**ADC Planning Consultation
Conservation/Design Officer Response**

Application Number	A/182/17/HH
Address	1 The Cottrells Angmering BN16 4AF
Description	Cladding to West elevation. This application may affect the character & appearance of the Angmering Conservation Area.
Case Officer	Mr J Baeza
Date	20 th December 2017

EXISTING WEST FACING ELEVATION

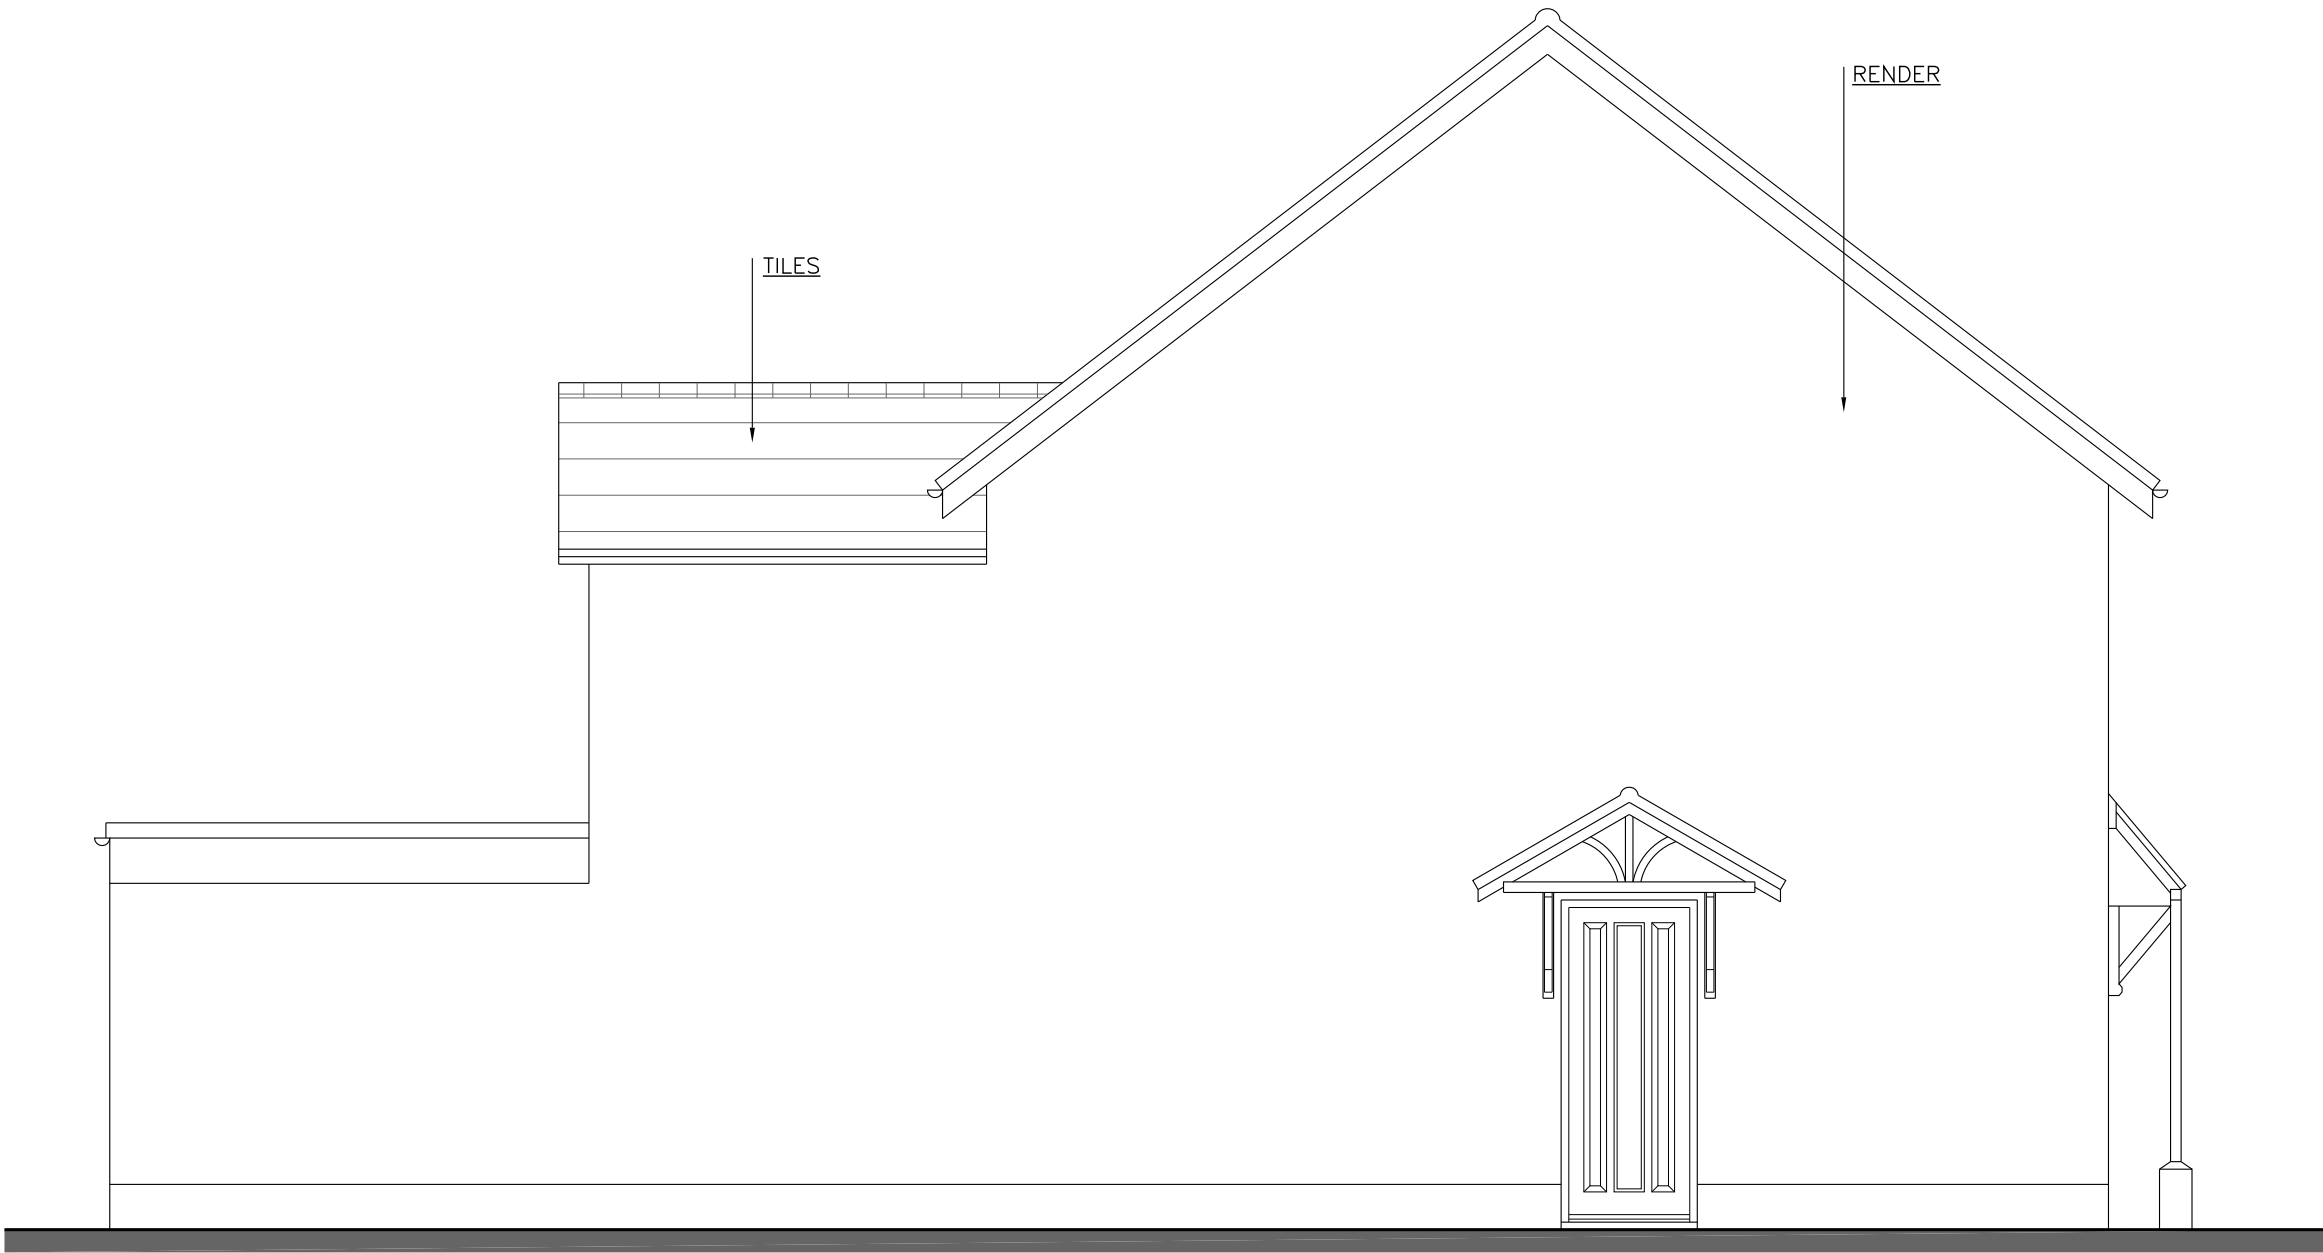
The application is retrospective, and Cedral cladding has been applied in part, and unfinished render is visible. It appears that the finish prior to this being applied was off-white render.

These cottages are brick, with render applied to the exposed end. This was previously painted off white and it is recommended that this be retained.

PROPOSED WEST FACING ELEVATION

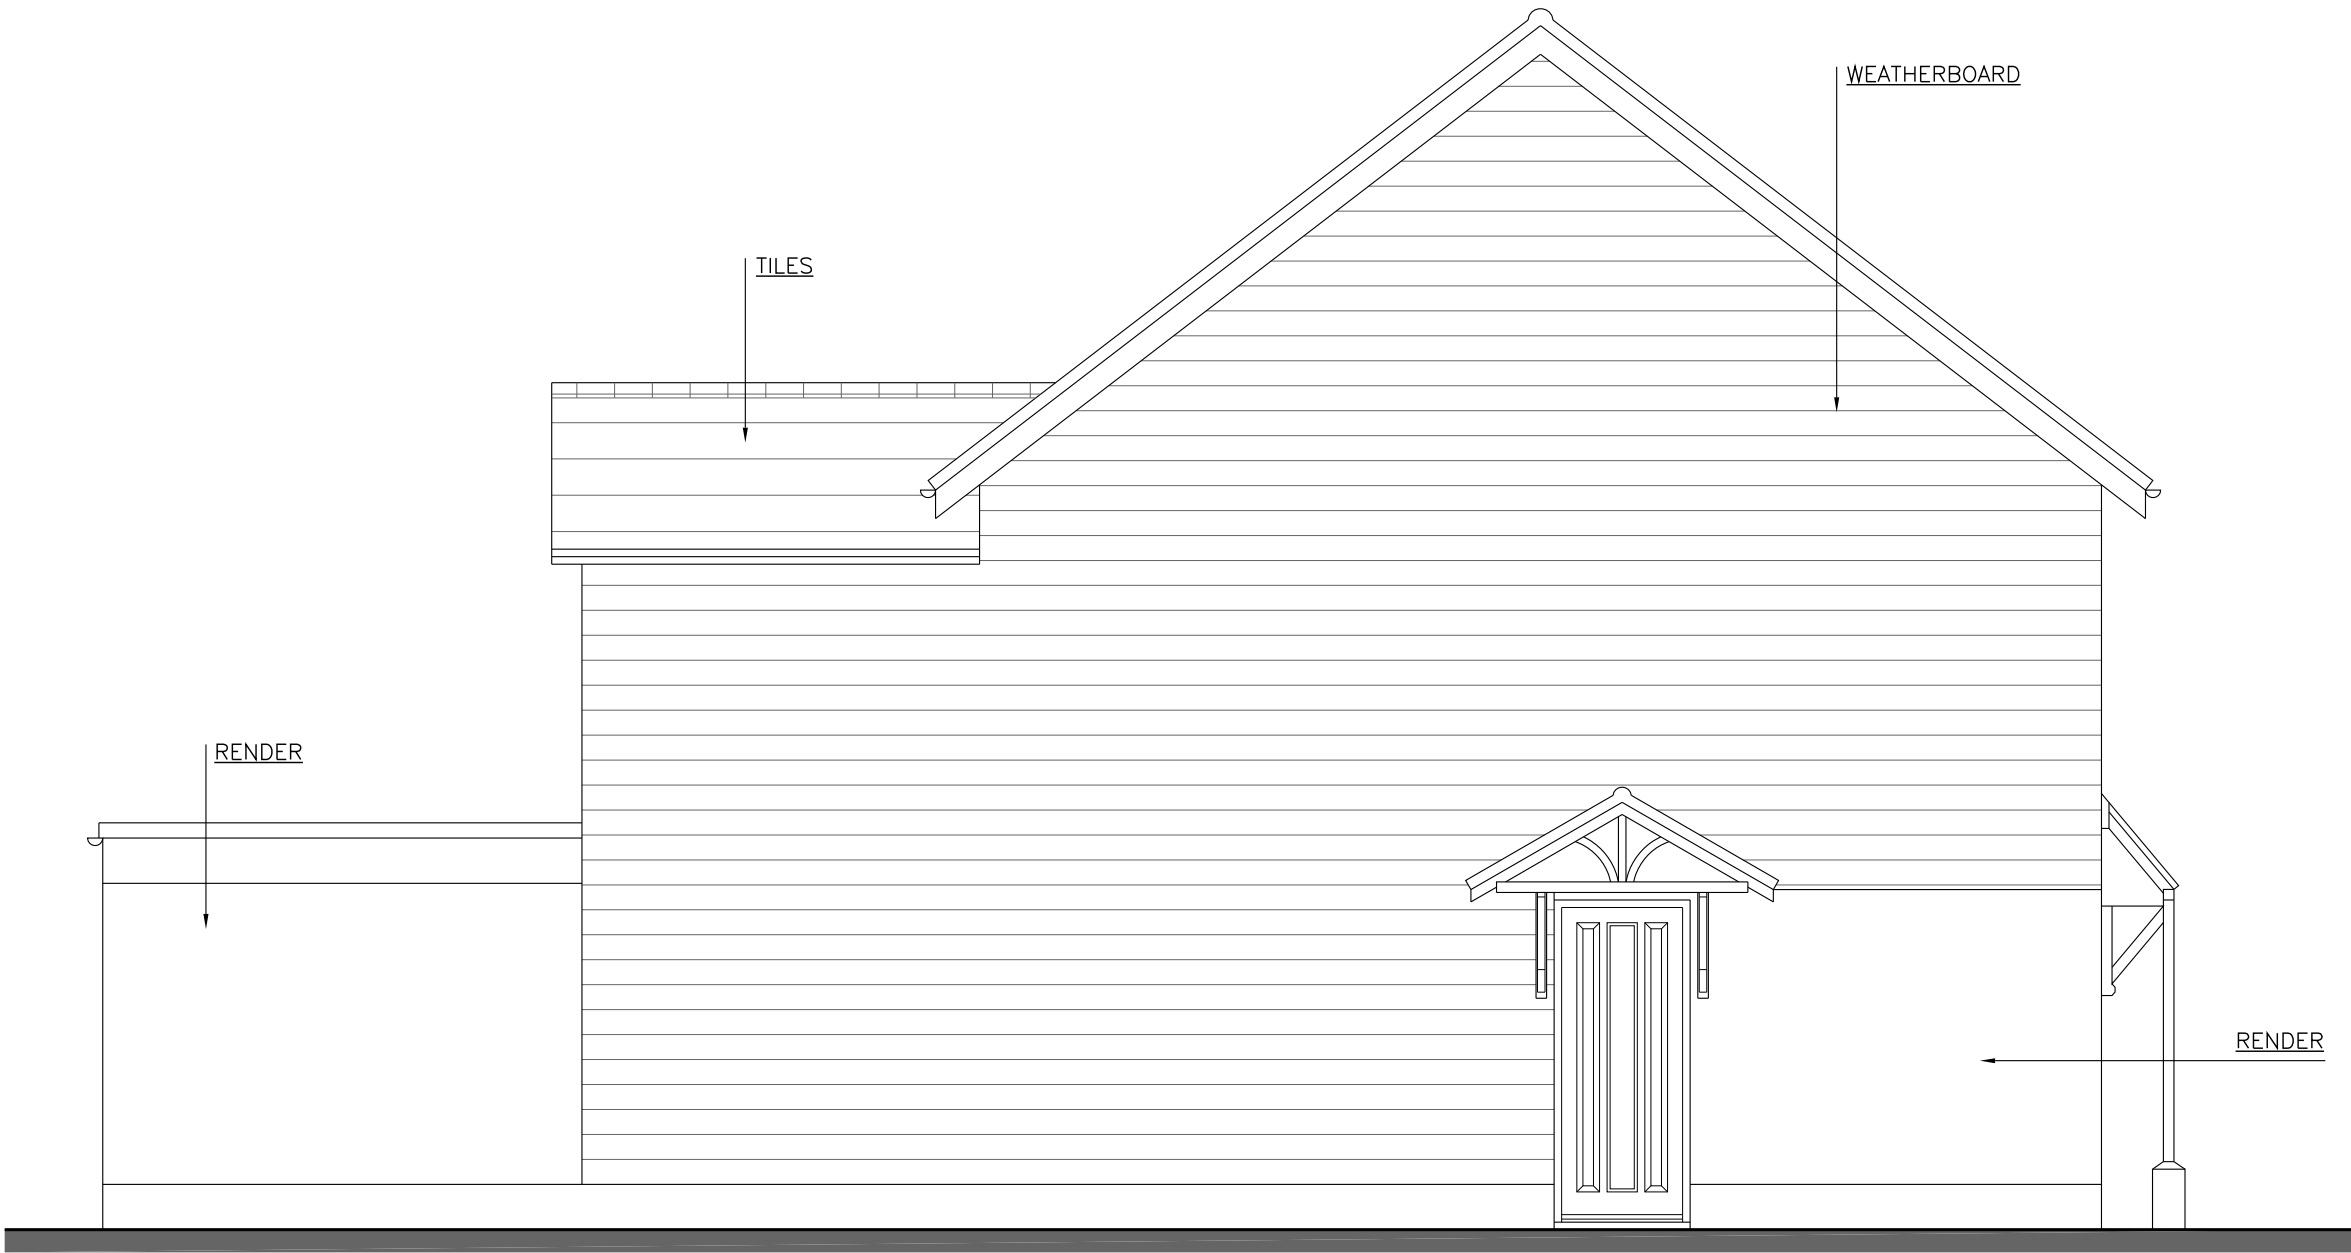
The site is close to the boundary of the Angmering Conservation Area, and is visible from it. The application is to part render and part clad the West elevation.

It is considered that the Cedral cladding is obtrusive and is out of keeping with the adjacent Conservation Area in terms of colour, detail and finish. The 'natural grain' finish is not imitative of properly prepared woodwork, and the product has a synthetic sheen, which detracts from the property and those adjacent.
